MP-2007/70/A

Development	Demolition of the existing structures, construction of a signalised intersection and development of a new 8 storey, 154 bed, medical and health facility (Wollongong Private Hospital) – Modification 1
Location	364 Crown Street, WOLLONGONG NSW 2500, Cram House, 360-362 Crown Street, WOLLONGONG NSW 2500, 9 Urunga Parade, WOLLONGONG NSW 2500, 11 Urunga Parade, WOLLONGONG NSW 2500

I refer to your letter dated 19 July 2013 seeking Council's comment in regard to the Donald Cant Watts Corke Pty Ltd (the proponent) request to modify the above project pursuant to Section 75W of the Environmental Planning and Assessment Act 1979.

Council has reviewed the modified proposal and raises no objection to the proposed changes; however the following comments/conditions as attached are requested to be considered in the Department's assessment of the modified proposal.

Drawing Title
DETAIL - MAIN HOPITAL SIGNAGES
FRONT FACADE

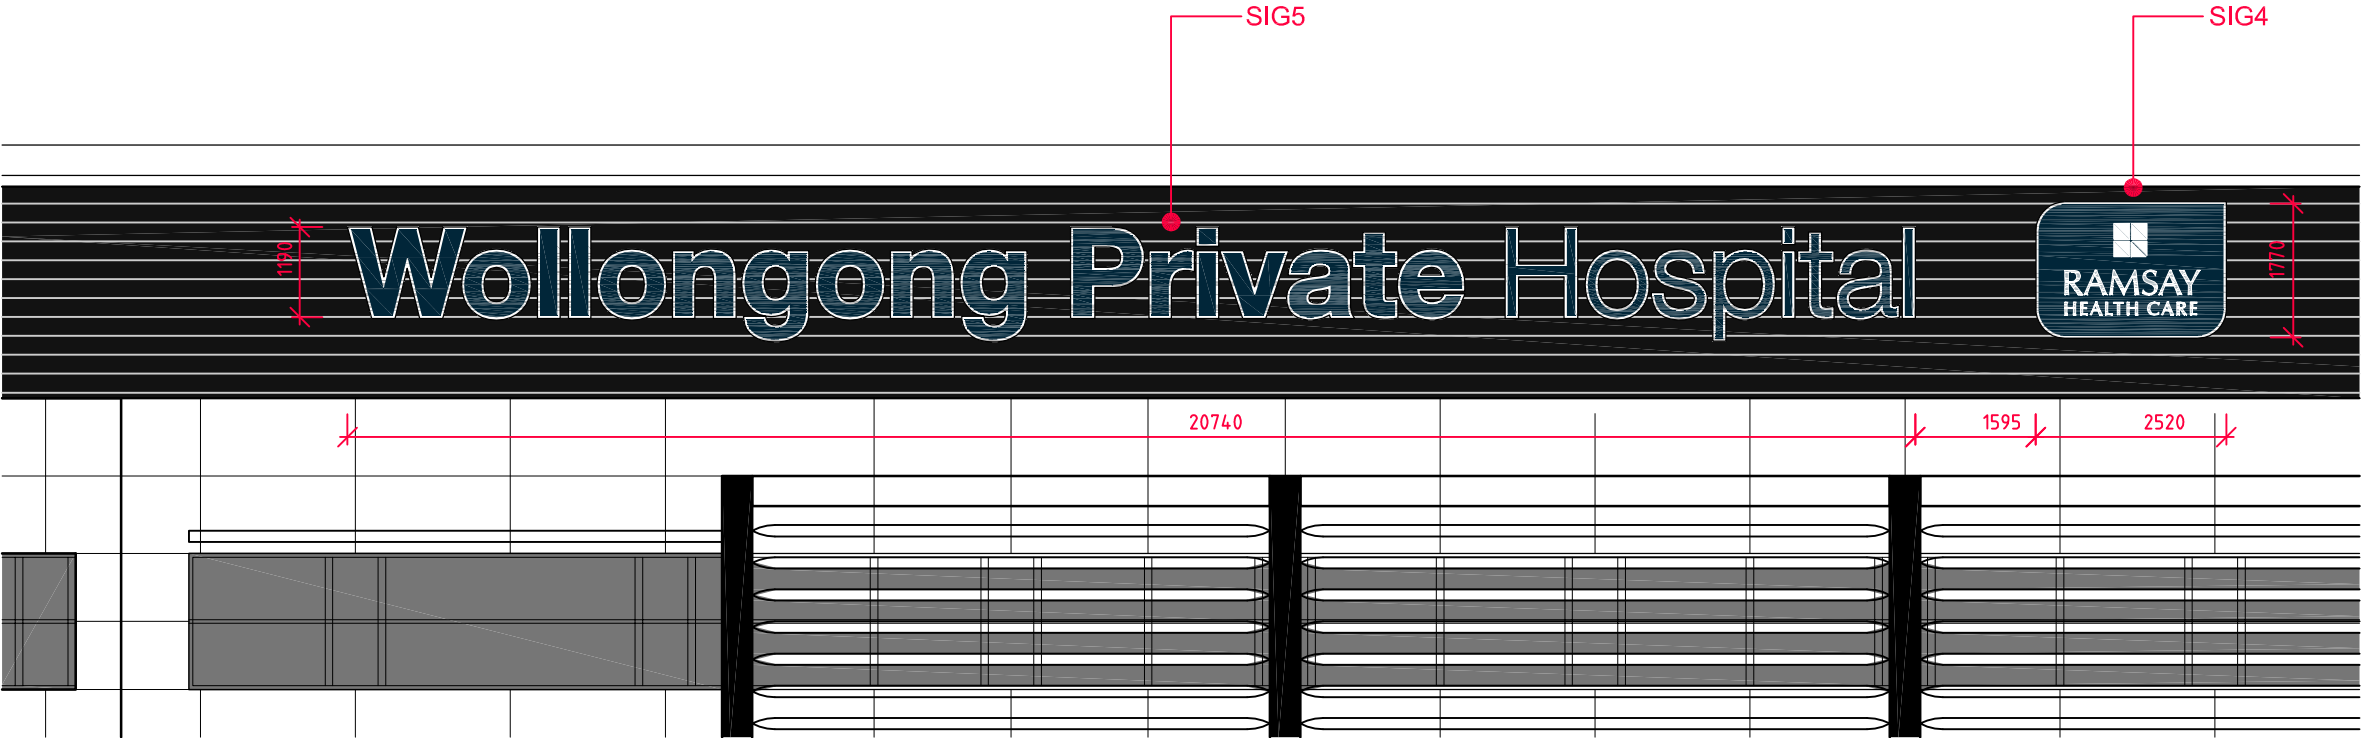
2. Heritage	
	<p>The proposed altered building works are generally similar to the previously approved, and thus this part of the proposal is deemed generally acceptable. However, the proposed new signage appears excessive, both in terms of number of signs and their size and design.</p> <p>It is noted that there are nine signs defined in the proposal, organised in five locations/groups to be placed on three elevations (east, west and Crown Street). The largest of these signs (Nos. 5) spans over 20m and is 1.2m high. Each of the signs Nos. 5 and 7 spans over 17 metres, and is 1.2m high. Each of these three largest signs is accompanied with a company logo 2.1m wide by 1.5m high. Effectively, this creates signage groups which act as three individual oversized signs, each 20-25m wide and 1.5m high.</p> <p>With encircled backgrounds, this would create a signage area exceeding 90 square metres. This would seem to be in excess of a reasonably expected building identification and would have an adverse impact on townscape due to its undue size and subsequent visual prominence.</p>

<p>The textual contents of signage reads “Wollongong Private Hospital”. Interestingly, in this identification message the first two words are emphasized by bolding, while the third is not; this raises question why is the word “Private” prioritised over the word “Hospital” in such a way. In summary, the proposed building works are generally acceptable, however, it is deemed that proposed signage is overly large and it is recommended to:</p> <ol style="list-style-type: none"> Reduce dimensions of all proposed signs by about 50% and In textual contents of all signs, apply consistent bolding (or lack of bolding) in all the three words of identification of the site as “Wollongong Private Hospital”.

T/S	Checked	Scale	Revision
PROPOSED OSD 'B' DETAILS	B.SHROY	A.Francis	SHOW @ A1
'Storm'tech' CHAMBER OSD SYSTEM	B.SHROY	A.Francis	SHOW @ A1

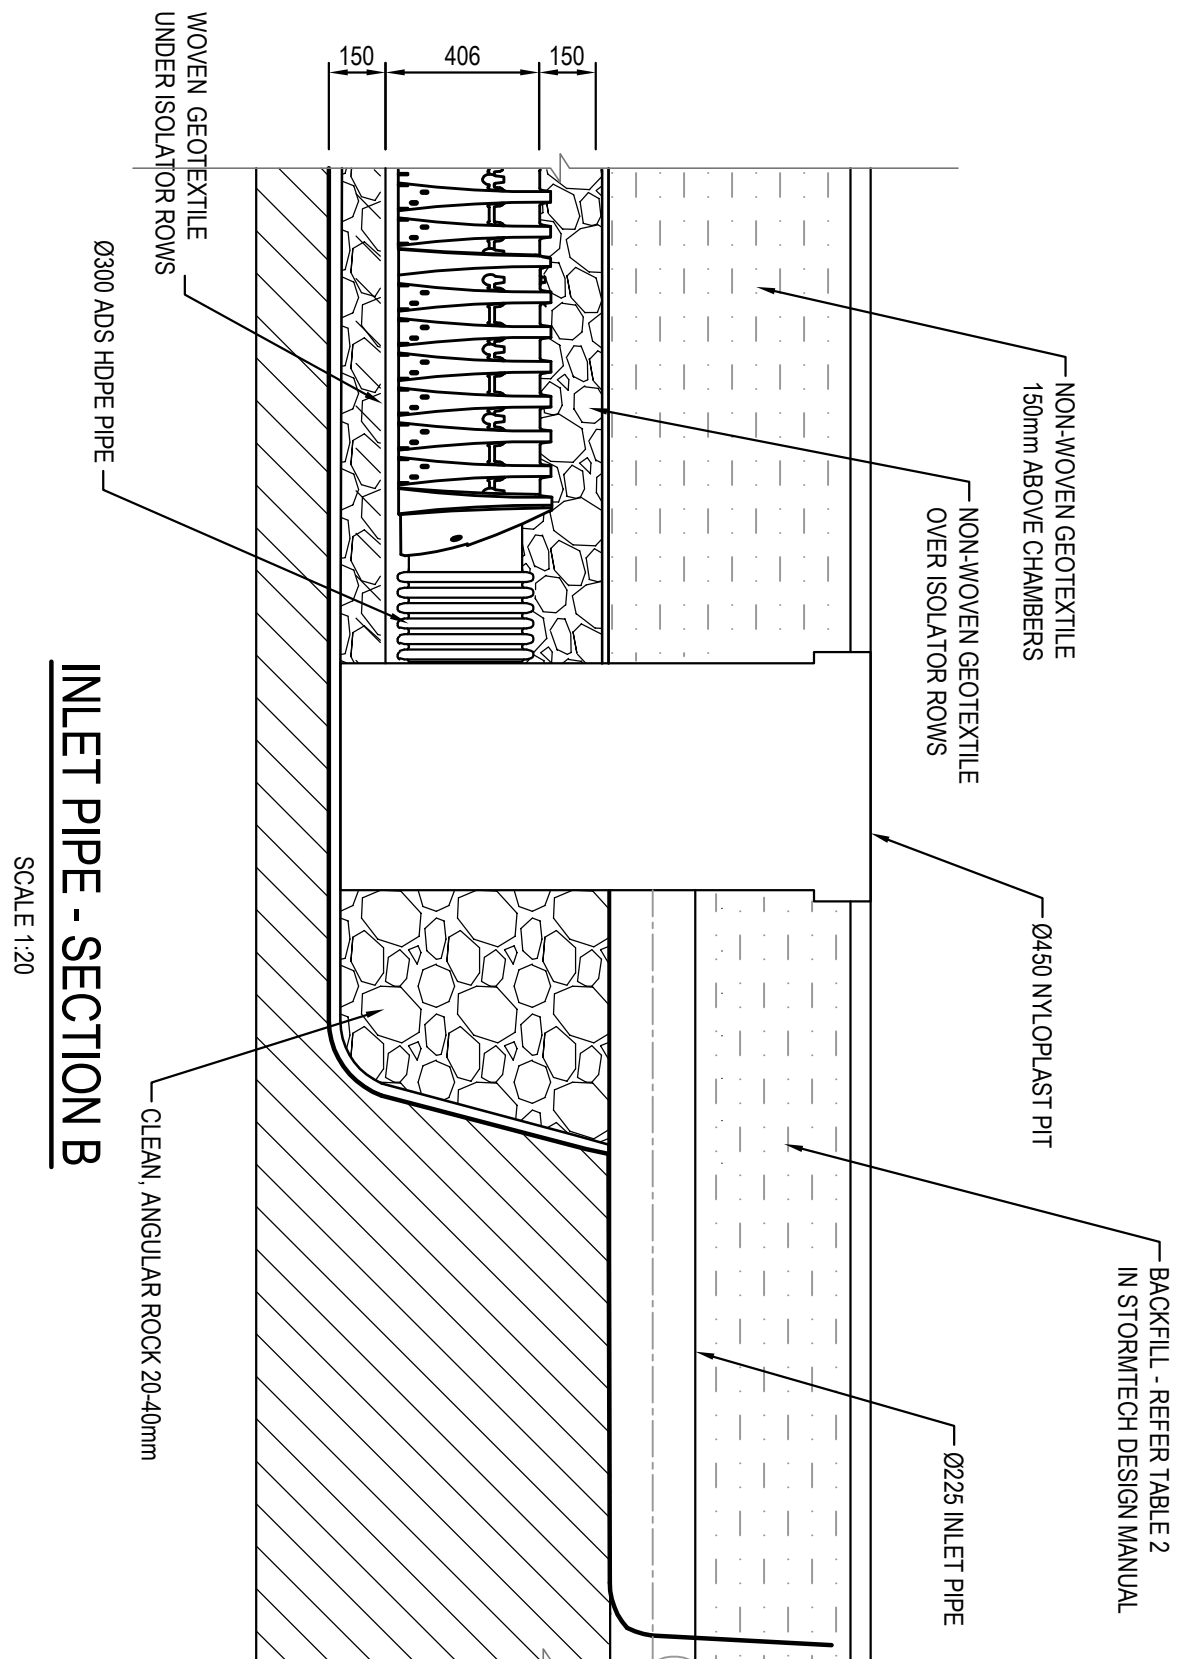
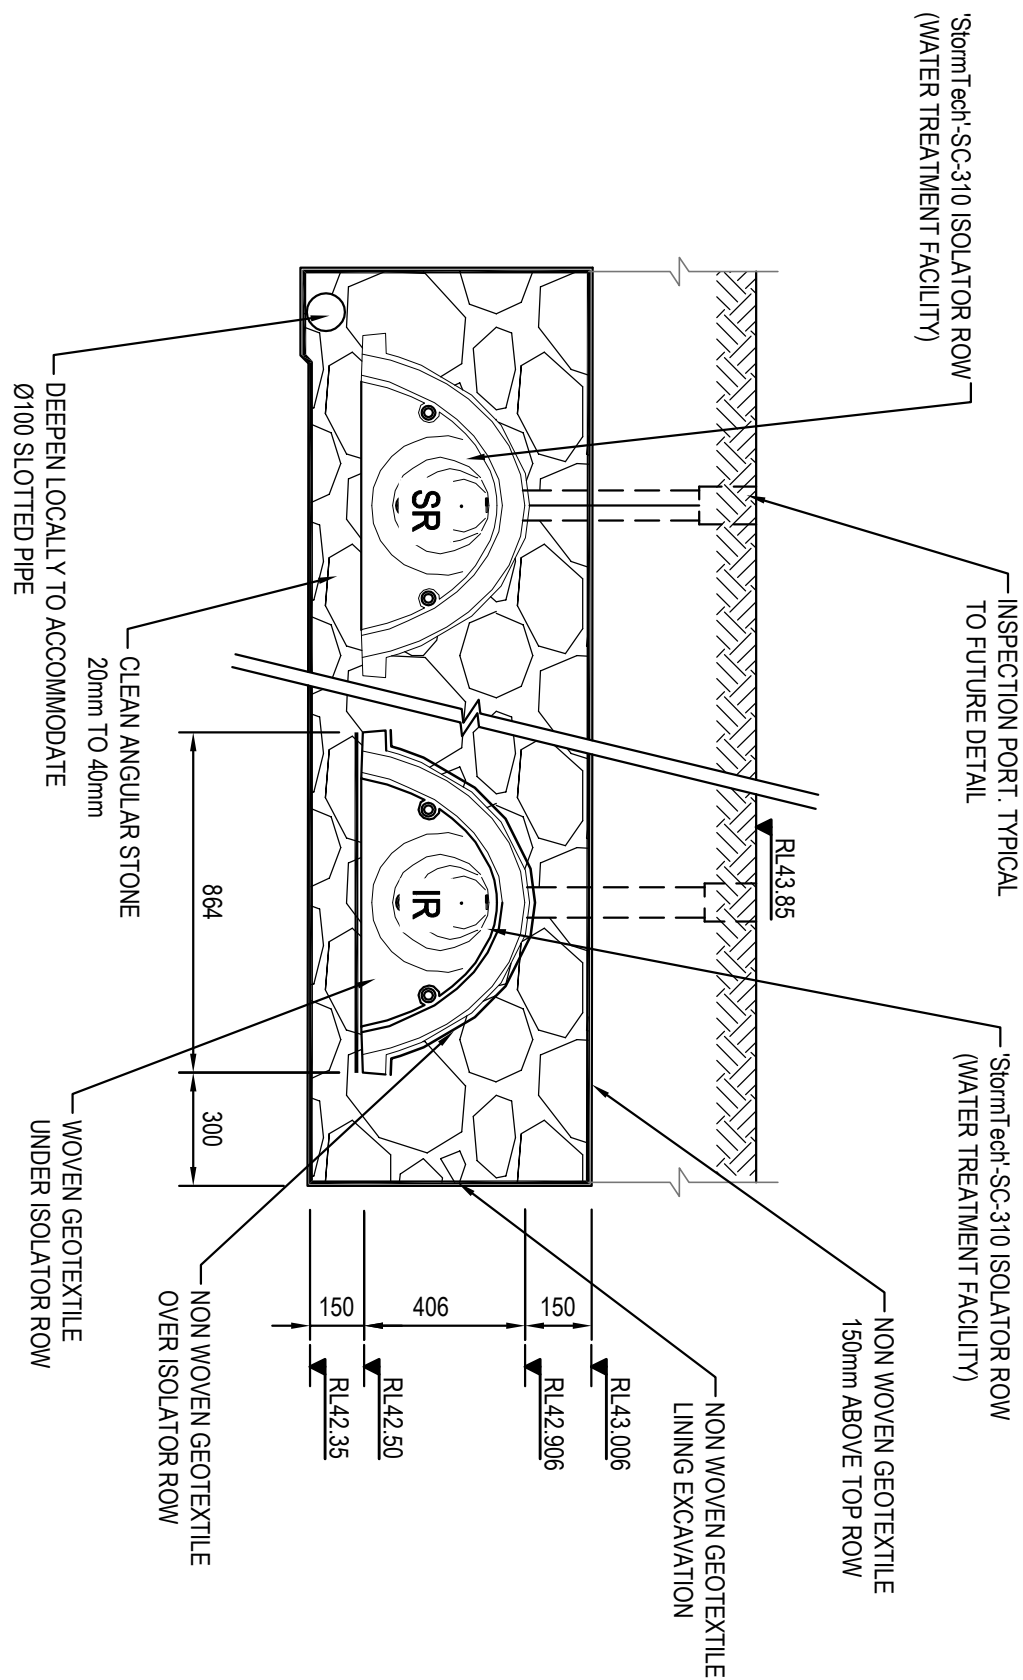
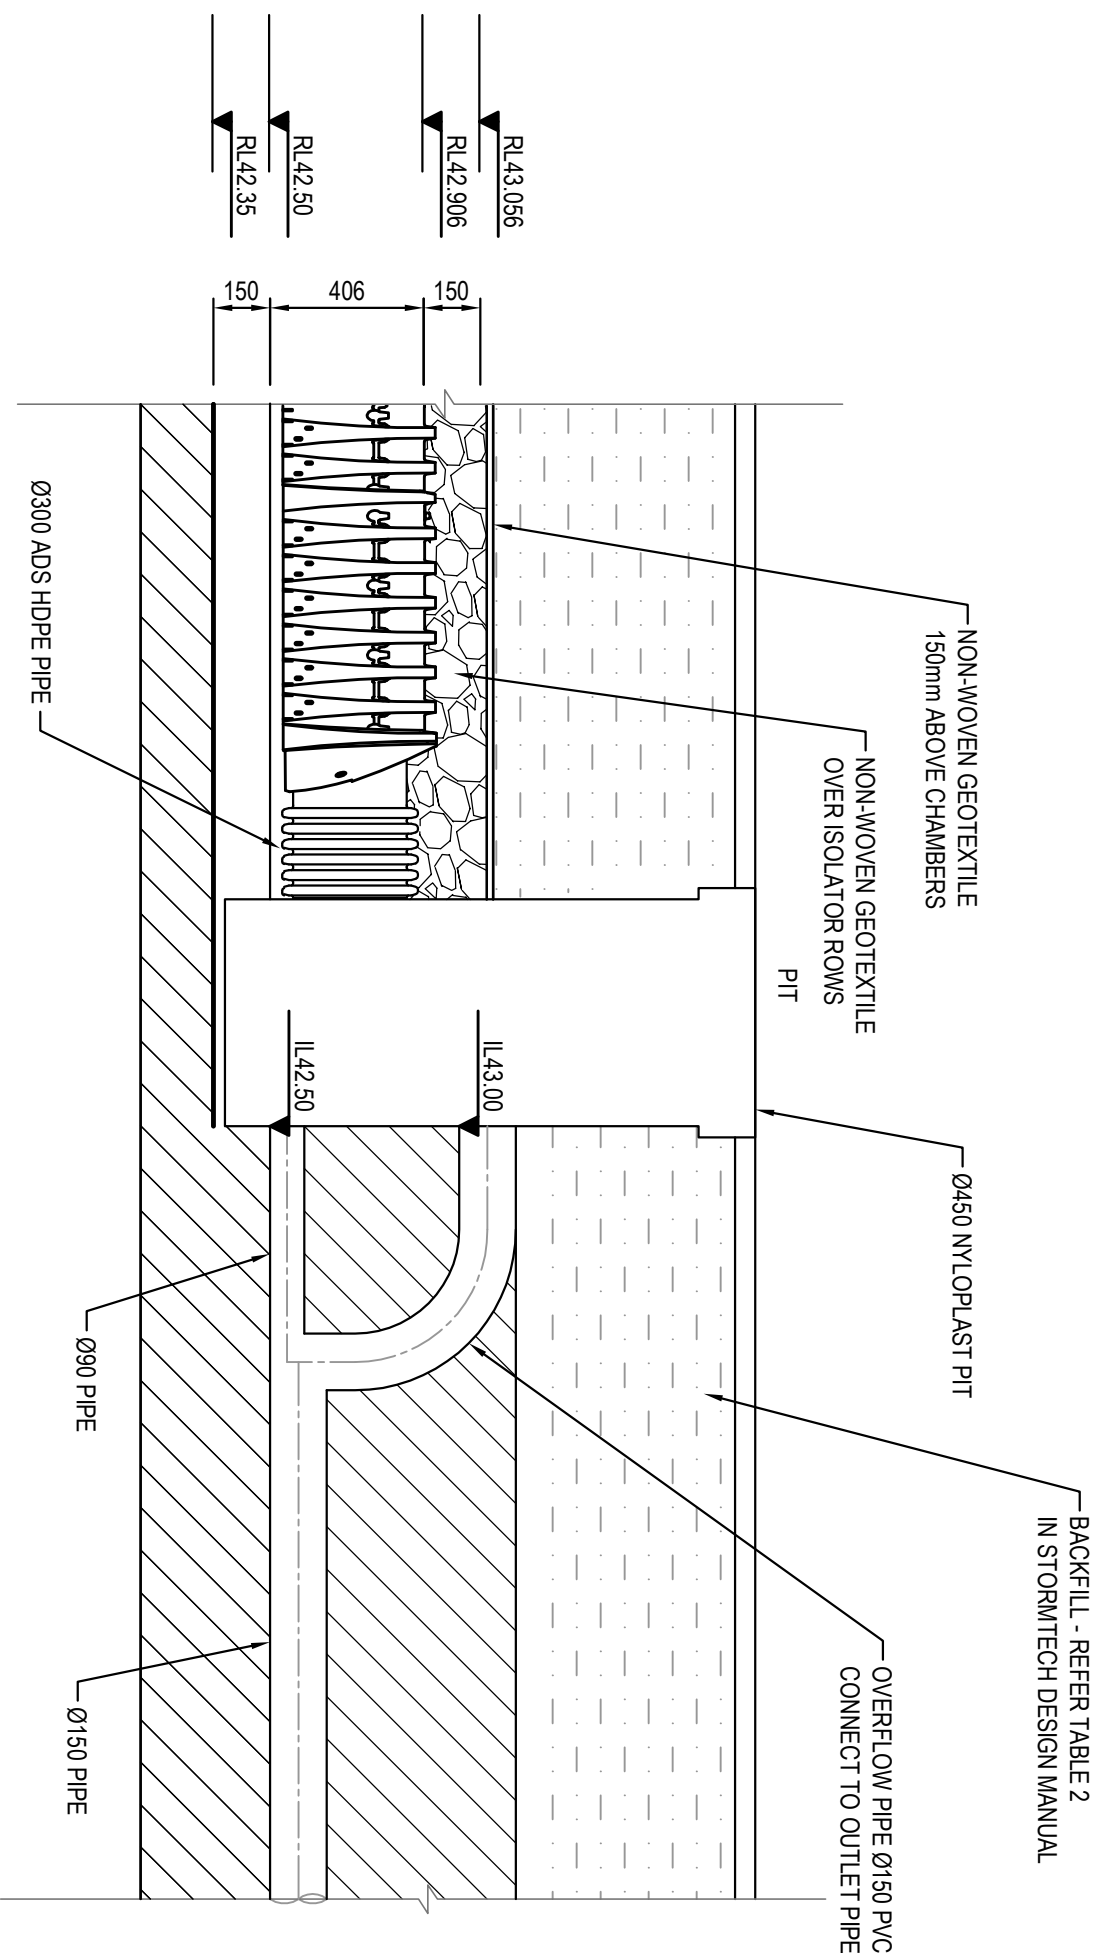
3. Stormwater	
	<p>Section 5.6 of the report by McKenzie Group Consulting Planning dated July 2013 indicates that on-site detention is now considered necessary due to the increase in impervious area (assumed for catchment B). However there is no increase in impervious area for Catchment B according to the civil plans by Henry & Hymas, which actually show a decrease in impervious area from the pre-developed case.</p> <p>The on-site detention system proposed for Catchment ‘B’ is in conflict with the landscape plan. In particular the ‘StormTech’ chamber detention system is in conflict with the feature trees proposed along the Crown Street frontage. The proximity to the trees has the potential to significantly damage the detention system and result in a loss of integrity of its main functions to detain stormwater and convey flows to the street.</p> <p>Other potential issues with the proposed chamber detention system include difficulties with access and maintenance, the inability to detain stormwater due to the permeable membrane, and the potential loss of available storage volume due to the ingress of surrounding groundwater flows through the permeable membrane.</p> <p>With respect to the above items, an alternate stormwater management design is required for Catchment ‘B’. It is requested the alternate design be submitted to Council for further review prior to the issue of the modified Project Approval.</p>
